**Addendum No. 2**

RE: Contract ID C203357

**Gaston County (I-4928)**

I-85 NBL Weigh Station From SR-1302 (Crowders Mountain Road)

1 SITE PLAN
U2 SCALE: 1'-0"=10'-0"

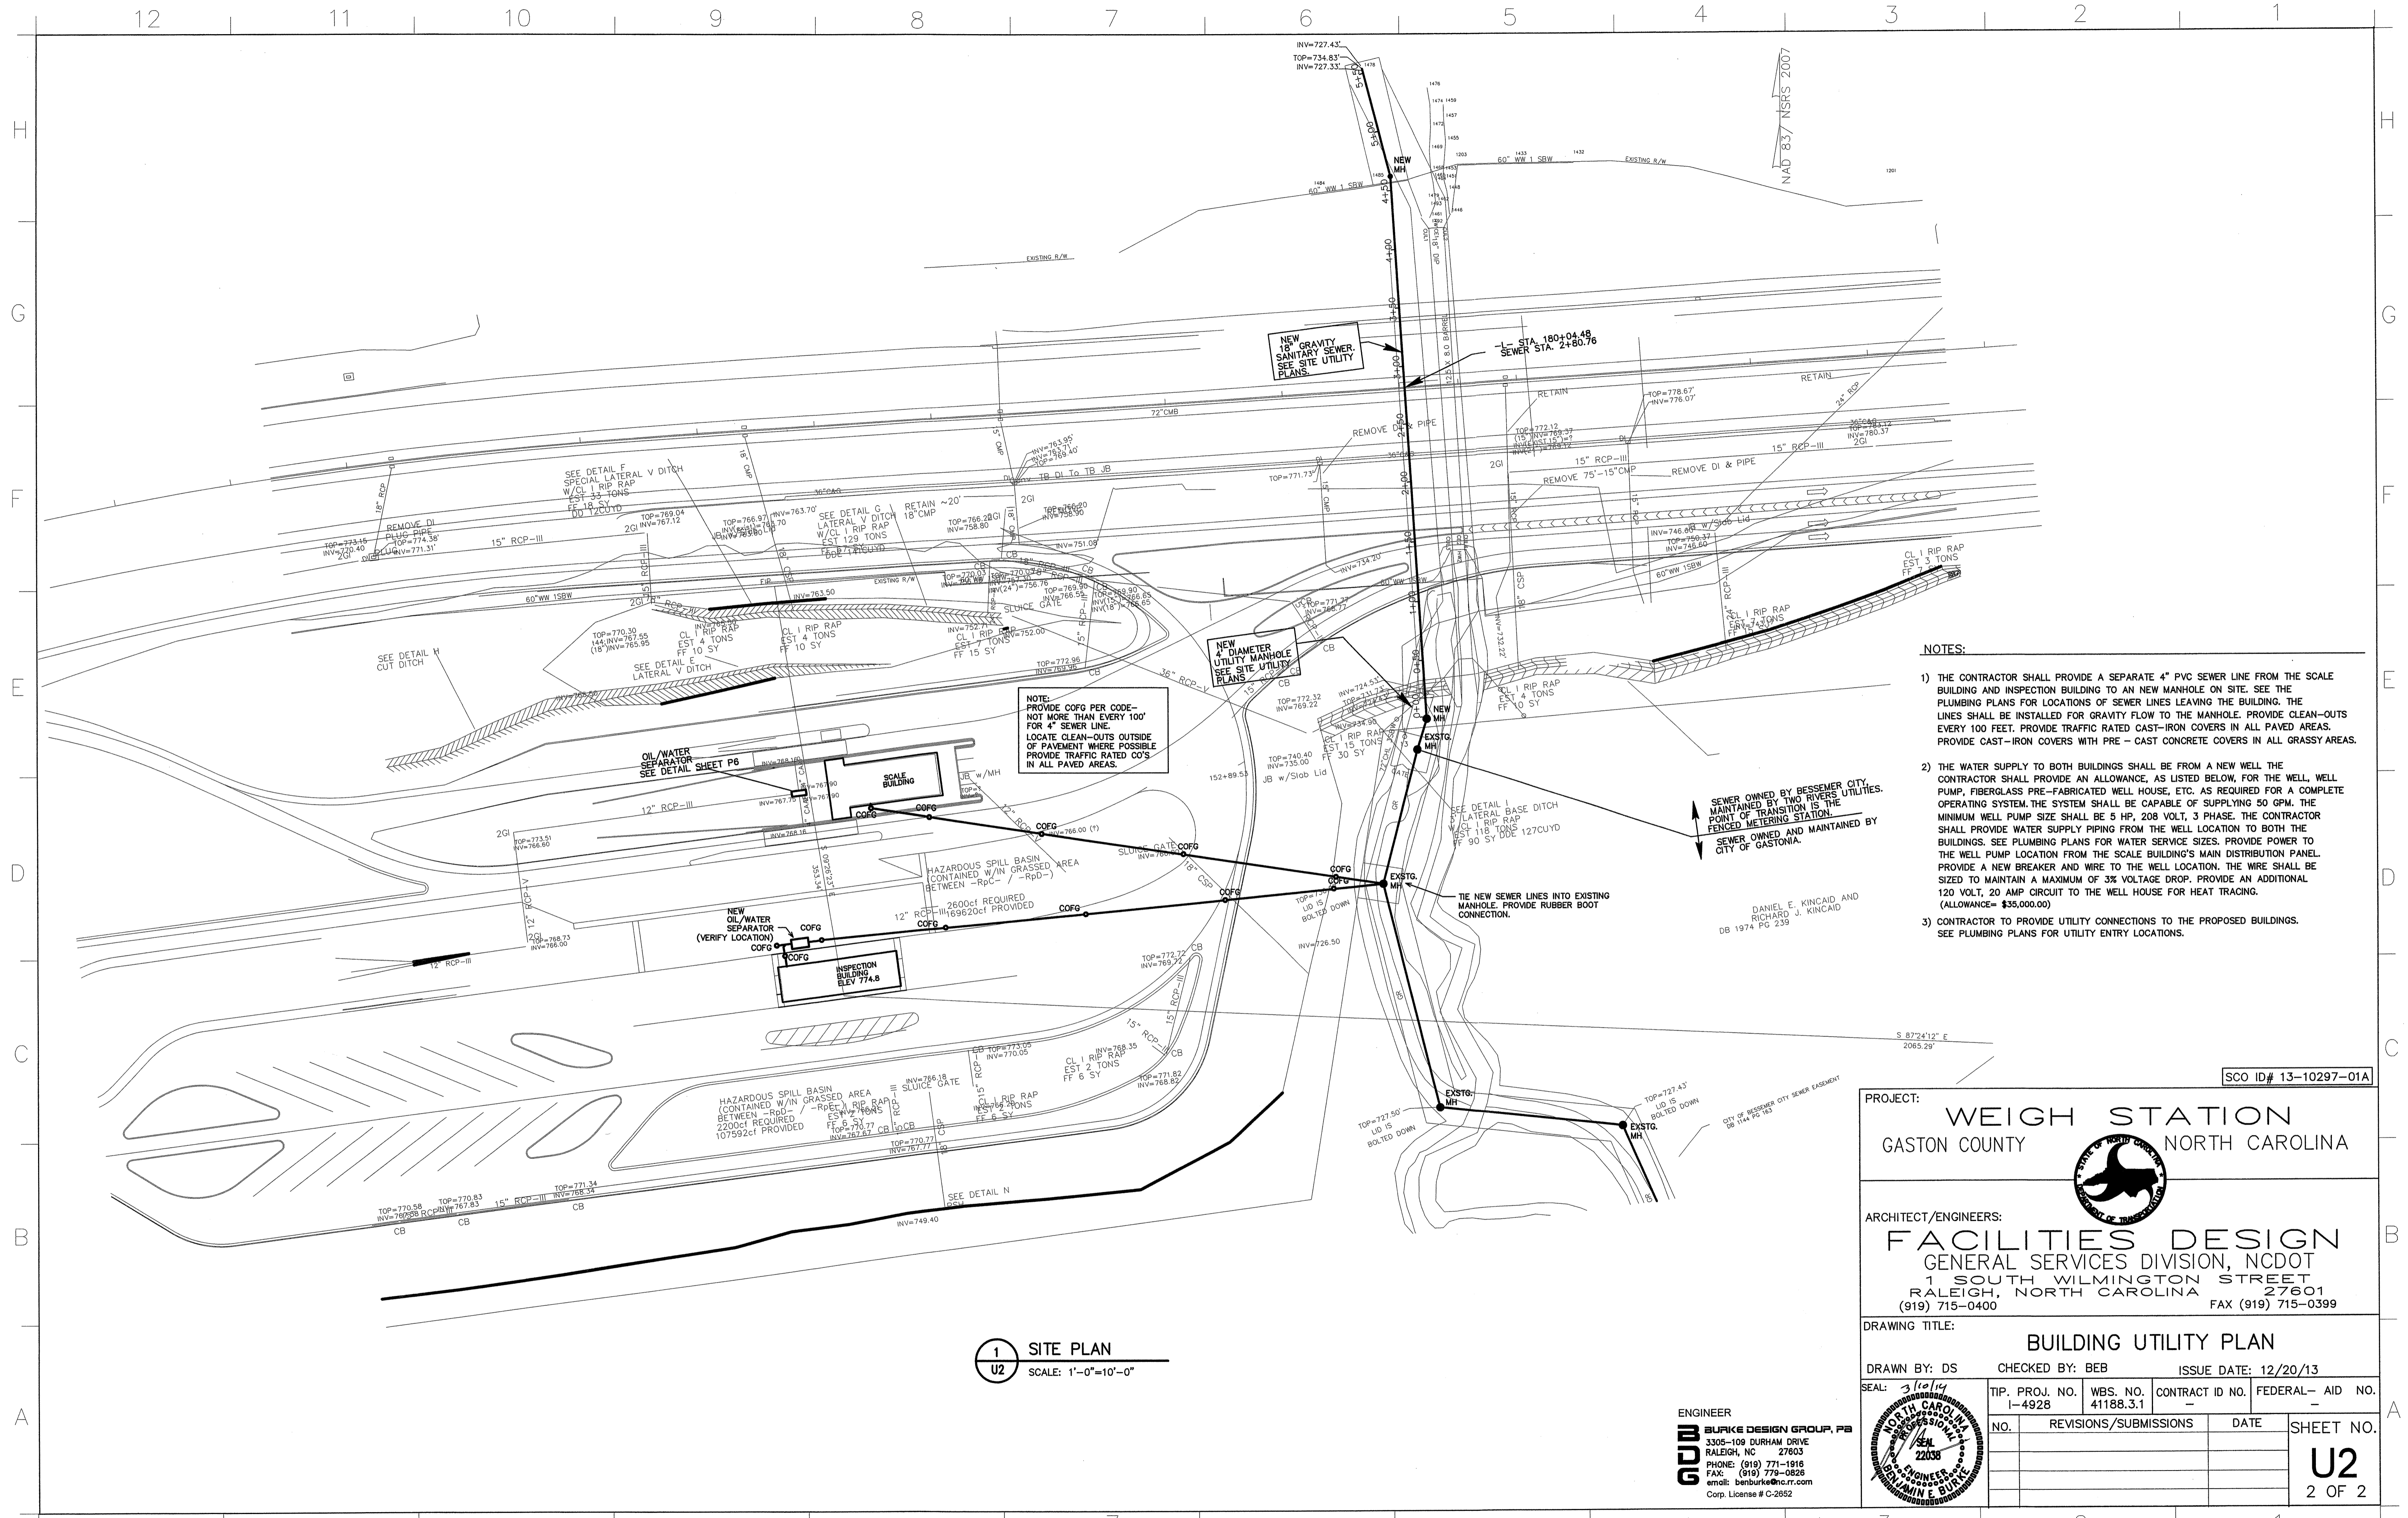
- 1) The contractor shall provide a separate 4" PVC sewer line from the Scale Building and Inspection Building to an existing manhole on site. See plumbing plans for locations of sewer lines leaving the building. The manhole is due west from the building locations. The elevation of the top of the man-hole is 730.07'. The manhole is located approximately 400 feet from the Scale Building and 480 feet from the Inspection Building. The lines shall be installed for gravity flow to the manhole. Provide clean-outs every 100 feet. Provide traffic rated cast-iron covers in all paved areas. Provide cast-iron covers with pre-cast concrete covers in all grassy areas.

- 2) The water supply to both buildings shall be from a new well. The contractor shall provide an allowance, as listed below, for the well, well pump, fiberglass pre-fabricated well house, etc. as required for a complete operating system. The system shall be capable of supplying 50 gpm. The minimum well pump size shall be 5 hp, 208 volt, 3 phase. The contractor shall provide water supply piping from the well location to both the buildings. See plumbing plans for water service sizes. Provide power to the well pump location from the Scale Building's main distribution panel. Provide a new breaker and wire to the well location. The wire shall be sized to maintain a maximum of 3% voltage drop. Provide an additional 120 volt, 20 amp circuit to the well house for heat tracing.
